01 1/2" BENT SPLICE PLATE (GALV) W/ 3/8" DIA HOLE FOR (3) 3/8" DIA F1554 THROUGH BOLTS.

65 High Street Deck & Stair Replacement

BY	JJO
NO	
DATE	08-04-2017
REMARKS	Issued for Fast-track Permit
CODE:	IRC 2009
TOWN	PORTLAND
DATE:	07-24-17
SCALE:	As Noted
DRAWN:	JJO
TITLE:	DETAILS
FILE:	
SHEET:	A1-03

(3) TYP. POST DETAILS

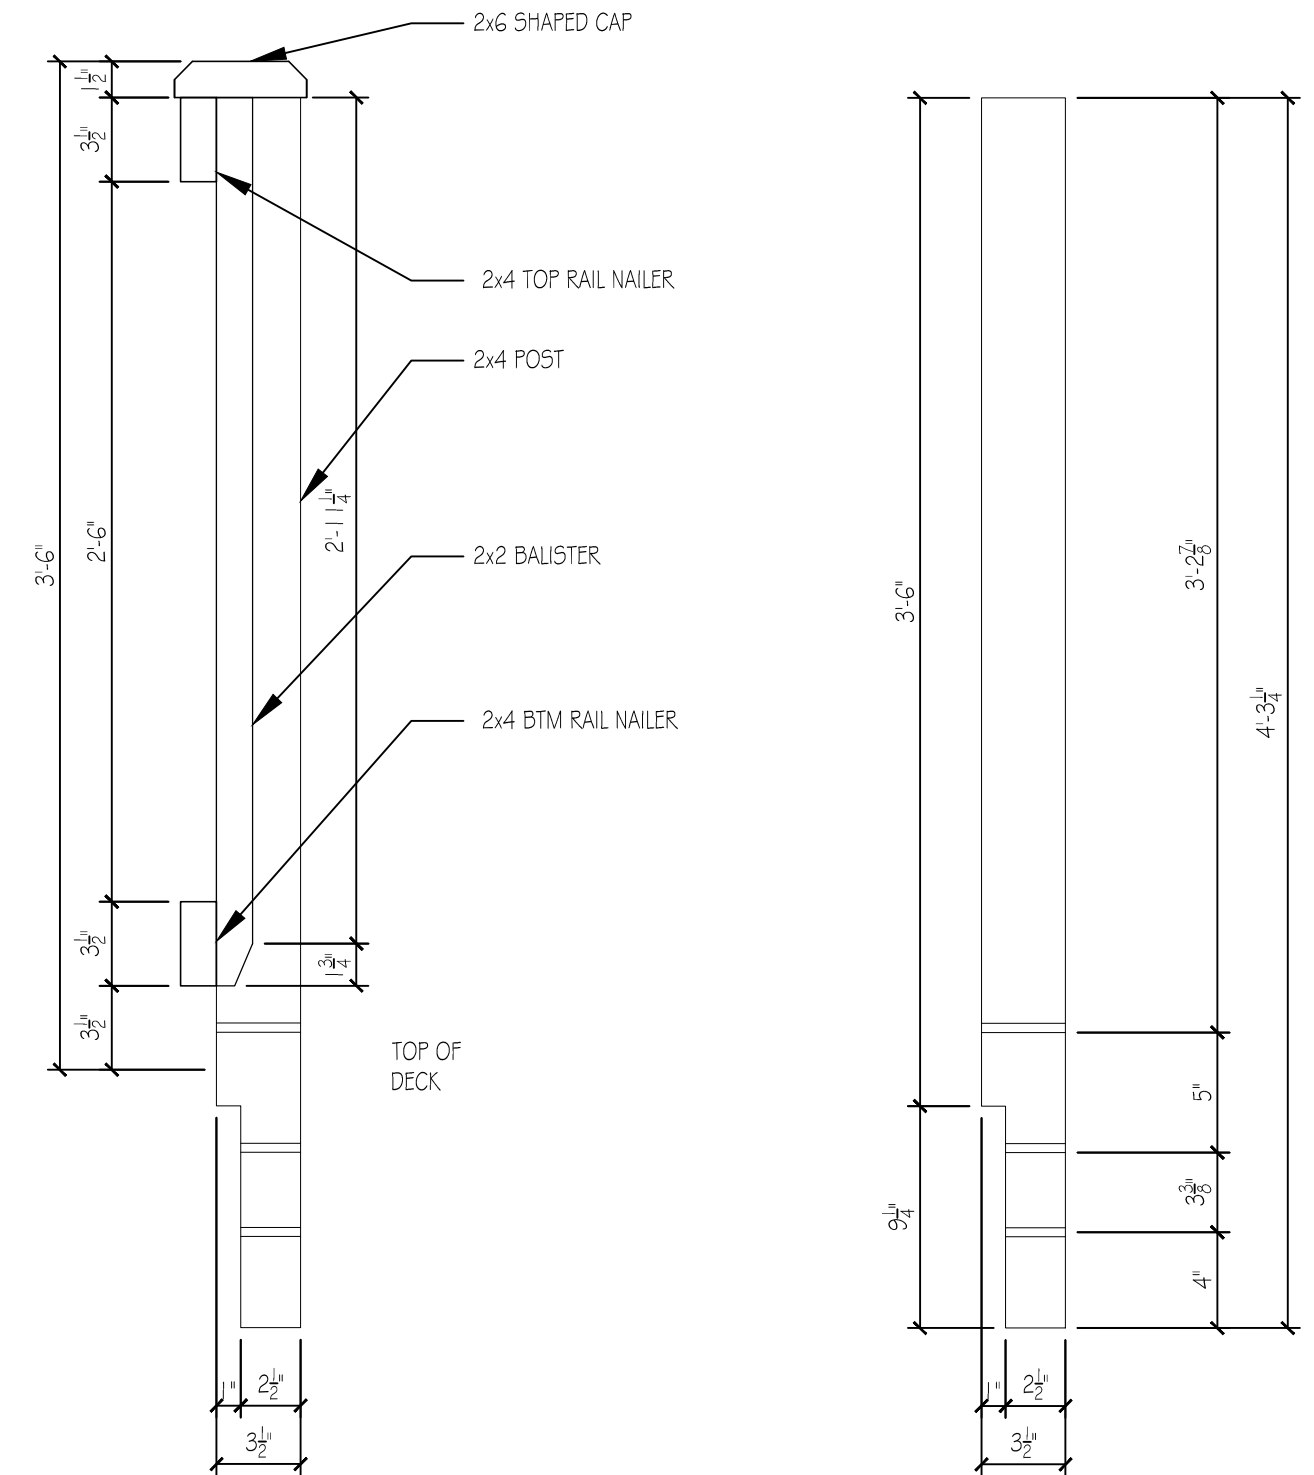
Please provide the post to pier attachment hardware
